**Planning Application, Ribble Valley District
3/12/0488 land at Ribblesdale Avenue, Clitheroe**

I refer to your letter of 13 June 2012 concerning the above application for the discharge of Reserved Matters.

SITE PLAN OF PLOT 1 AND 2

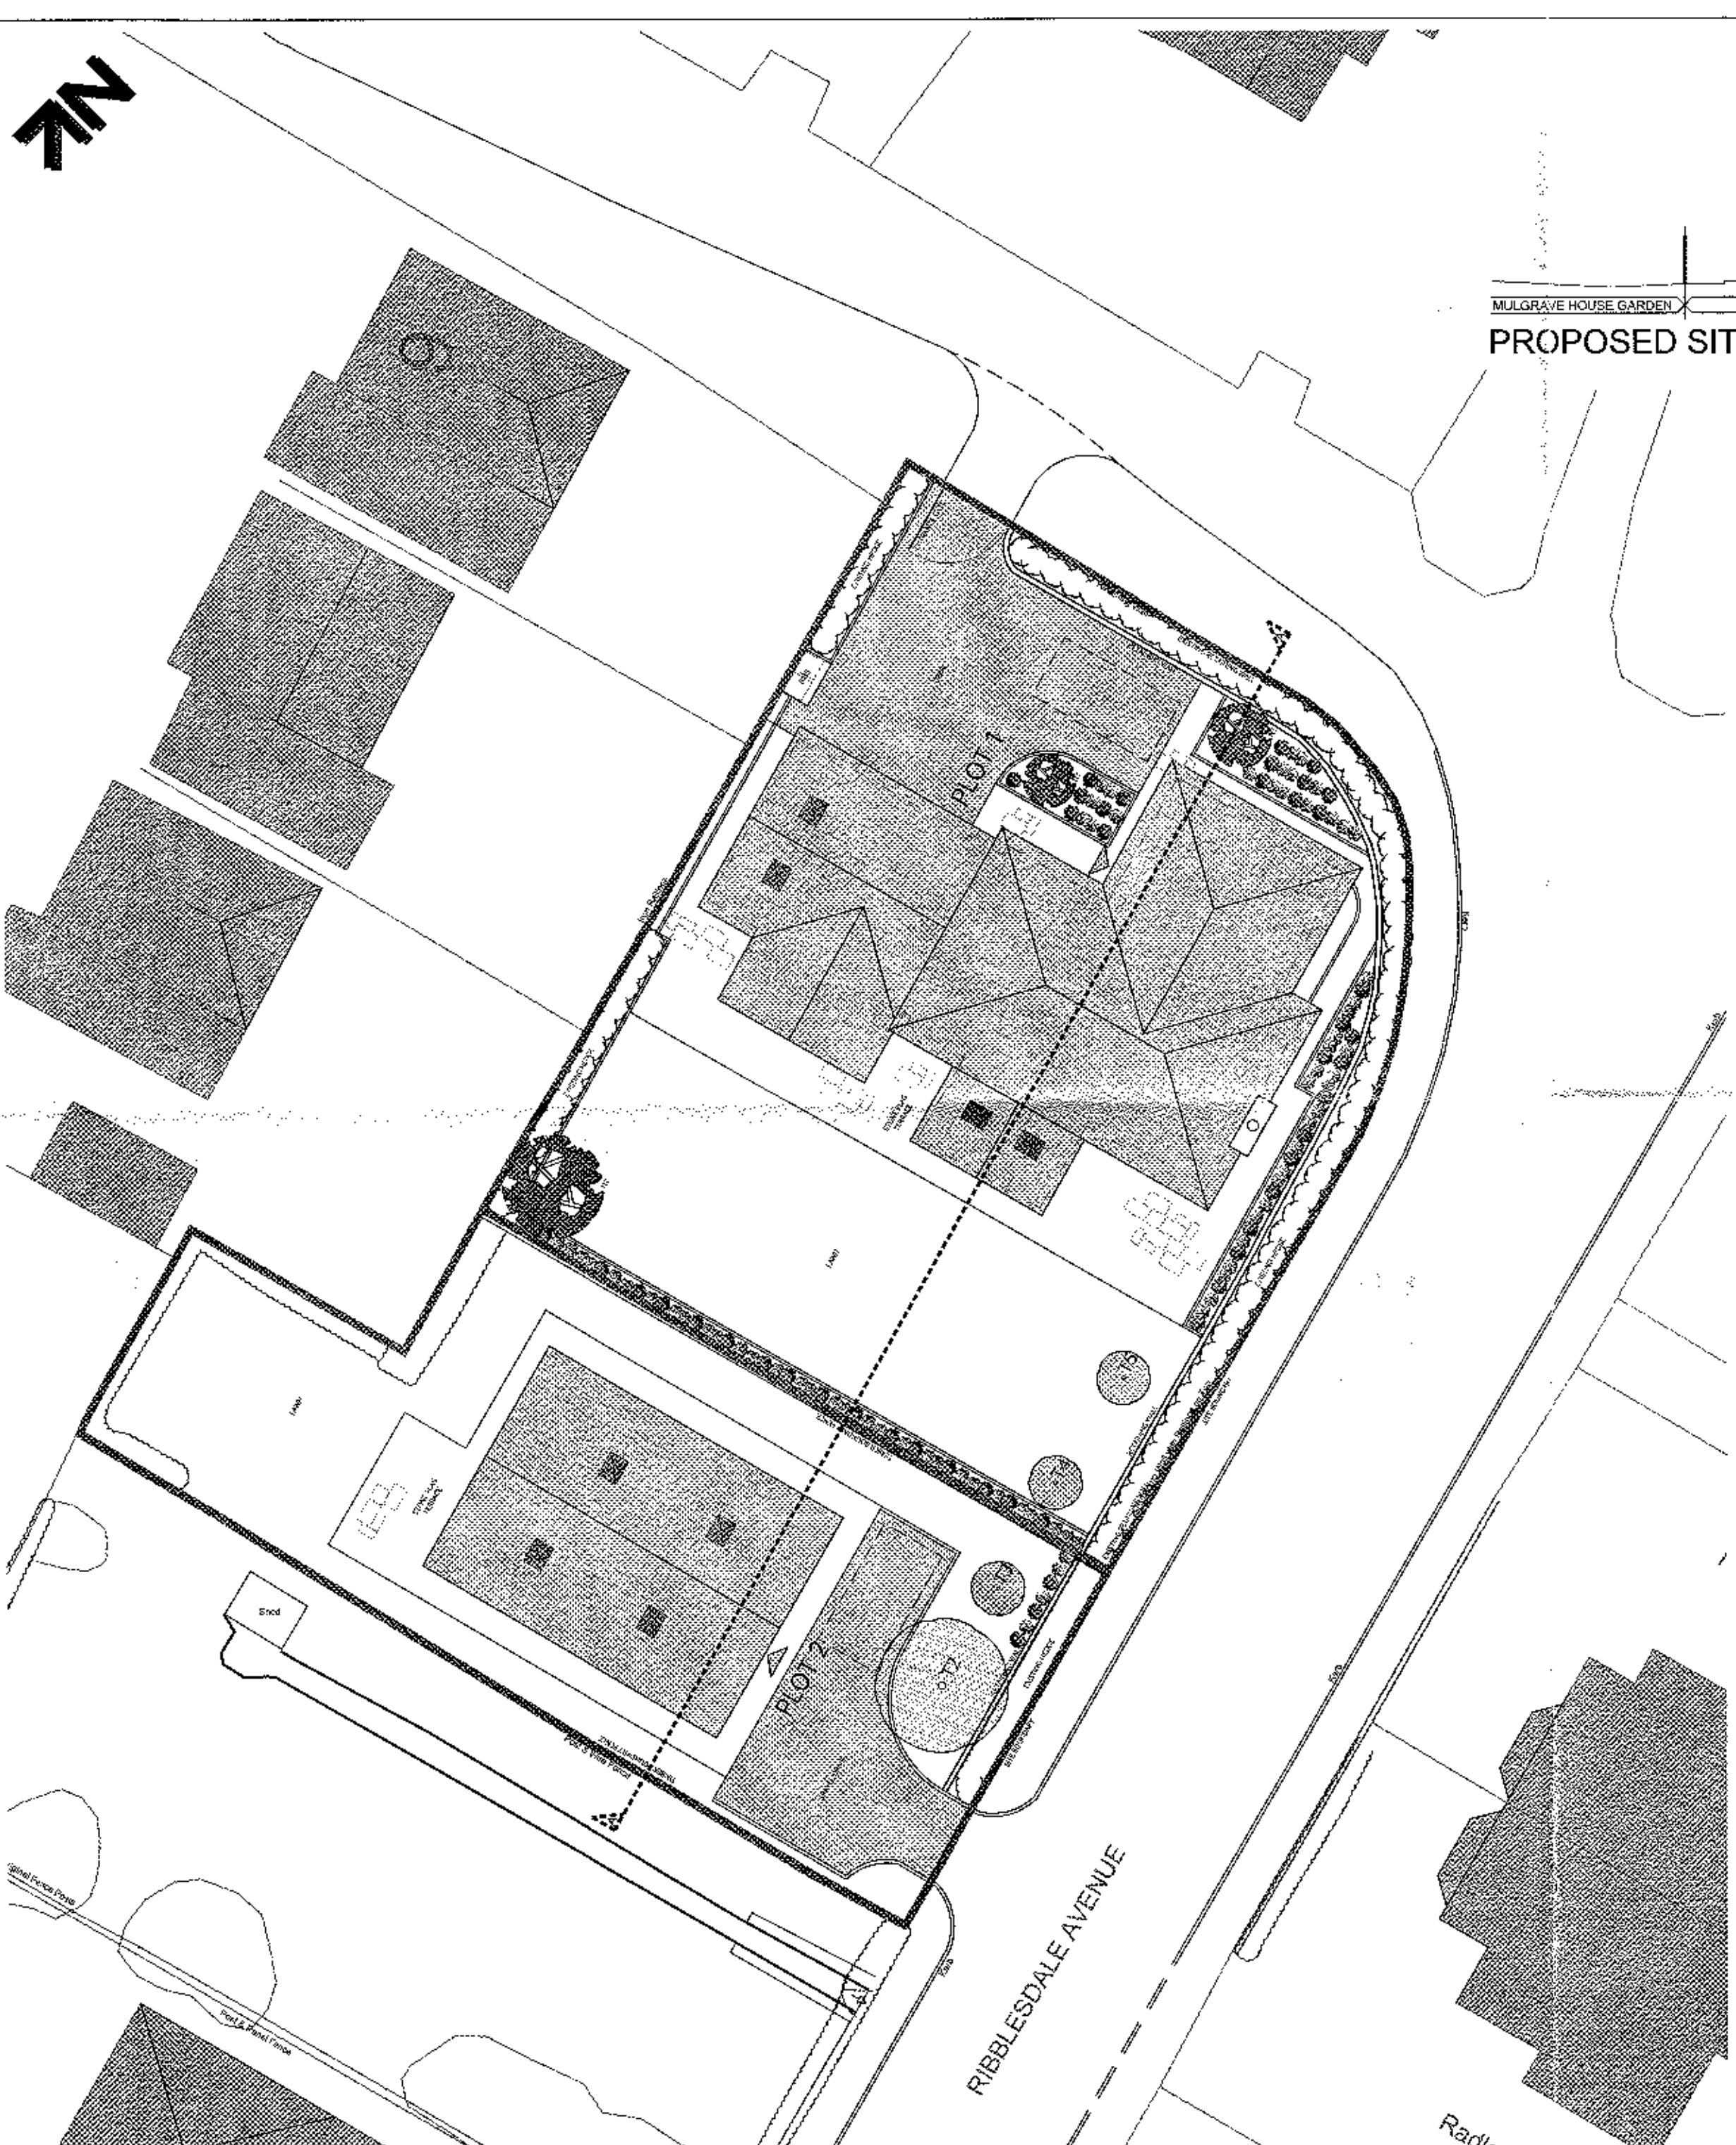
Plot 1 is shown as being accessed from the north and secures a minimum of three off street car parking spaces. This level of provision is appropriate for a four bedroom property.

I would recommend that a Condition be attached to any successful application that seeks to retain the use of the detached garage for its intended purpose and to prohibit any future conversion to residential living space.

Plot 2 is shown as being accessed from the west and secures a minimum of two off street car parking spaces. This level of provision is appropriate for a three bedroom property.
